Council Reference: DA08/1247
Your Reference: MP06_0030 (Mod 2)

30 April 2018

Proposed modification of the Dunloe Park Sand Quarry (MP06_0030 Mod 2) with regard to the proposed increase in heavy vehicle movements

Figure 4: Proposed vegetation removal in Pottsville Road reserve

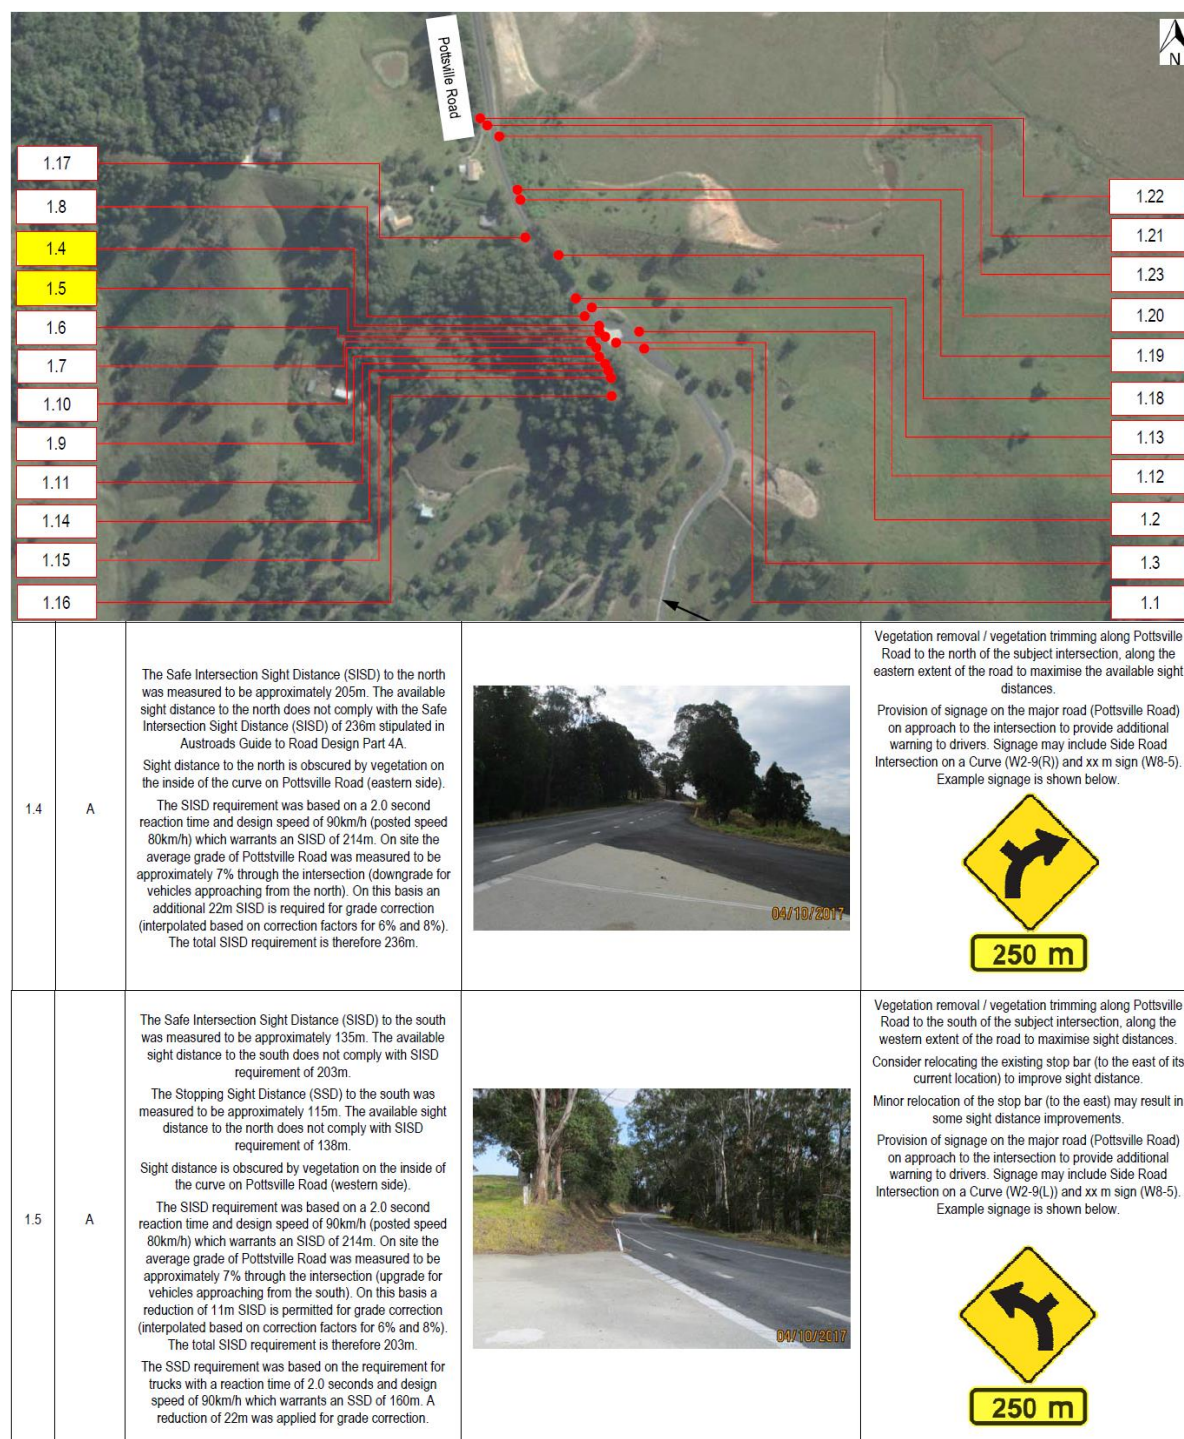
Accordingly, please be advised that Council does not support the recommendations of the RSA (which include significant tree clearing). Rather, it is considered appropriate that the Clear Zone provisions in GHD's draft Response to the RSA, dated March 2018 (as noted above) be adopted for the proposed development, with additional signage warning motorists that trucks may be entering the priority road.

Any works within the road reserve will trigger the requirement for a S138 approval from Tweed Shire Council as the road authority. However, it should be noted that assessment of any proposed vegetation removal is not supported to be part of a S138 application. In general, any works within a road reserve that do involve impact upon vegetation and/or other biodiversity values are assessed through a Development Application or Part V Review of Environmental Factors prior to any approval being granted.

The Proponent must implement all recommended road improvement works listed in Option 1 of Section 3.4 Clear Zone Assessment of the (Draft) Response to Road Safety Audit prepared by GHD, dated March 2018, in consultation with Council. Additional signage (as required by Council) shall also be installed. The works must be implemented prior to any increase in truck movements associated with Mod 2.
